Please upload the 3 attached REVISED drainage plans from the applicant onto Ocella for BE/135/18/PL – Salt Box.

Following our conversation please see attached amended calcs and drawings. Items as follows:

HYDROCK PROJECT NO.	SCALE @ A1
C-13319-C	1:500
STATUS DESCRIPTION	STATUS
INFORMATION	S2
DRAWING NO. (PROJECT CODE-ORIGINATOR-ZONE-LEVEL-TYPE-ROLE-NUMBER)	REVISION
SAL-HYD-00-ZZ-SK-C-7900	P02

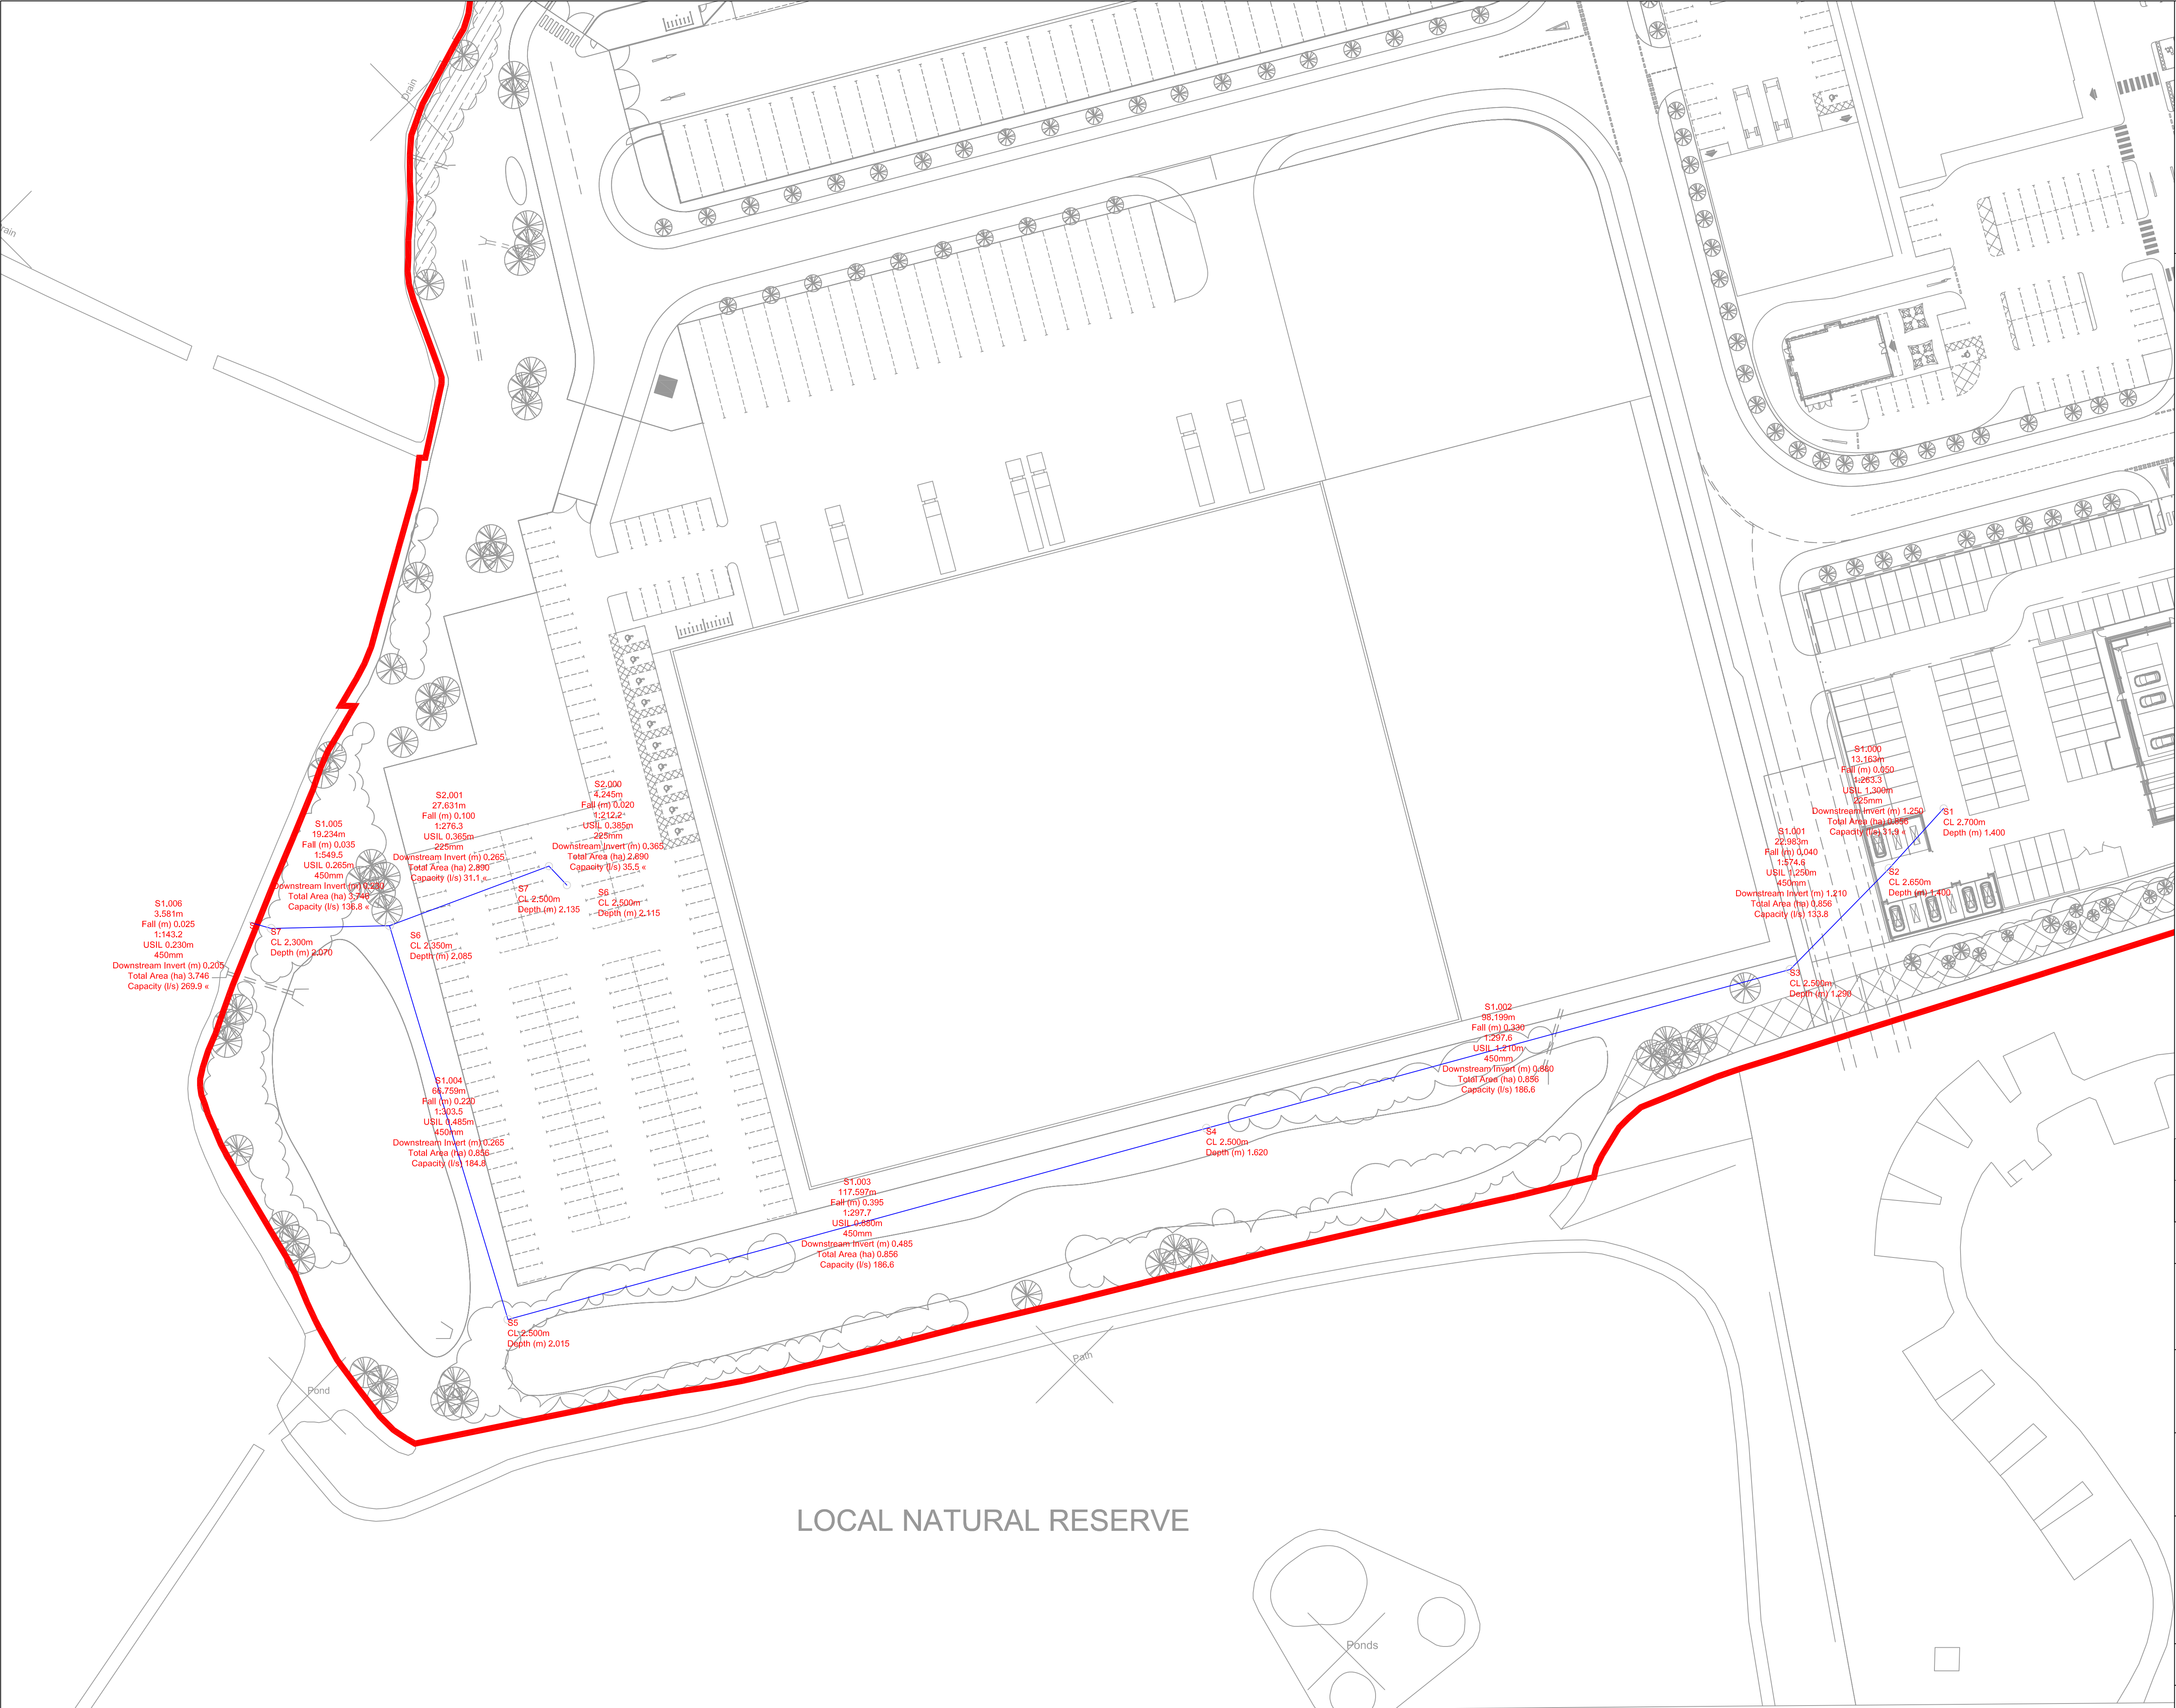
I note from SAL-HYD-00-ZZ-SK-C-7900_P02.PDF that you have raised the cover levels of S1 – S6 to above the 1.85m flood level. However, the other S6 & S7 (on network refs S2.000 & S2.001 have similarly been raised but they are within the car park – is this whole area to be raised – in which will this not affect the compensation calculations?

I also note that you have only corrected Network 2 tank Major Dim and not the resulting Xsect Area – still at 15m² does this have an effect on the MicroDrainage calcs?

SAL-HYD-00-ZZ-CA-C-0003 - Network 3 / SAL-HYD-00-ZZ-SK-C-7900 P03

- We have now moved the drainage runs S3-S5 into the hardstanding just outside Unit 1 to suit levels.
- Car park levels have not changed, the first Drawnet model had not updated to the required flood compensation levels, apologies for the confusion here.
- All levels around Unit 1 and car park are above the flood compensation and have been considered in the model. Cover levels should now reflect this.

- We have updated the culvert to amend the cross-sectional discrepancy (now 5000mm x 1500mm) at 7.5m² cross section.
- We have also allowed for the surcharge outfall and therefore increased the size accordingly (140m).
- Shows flooding at MH 57 and 58 (because cover levels at 1.800).
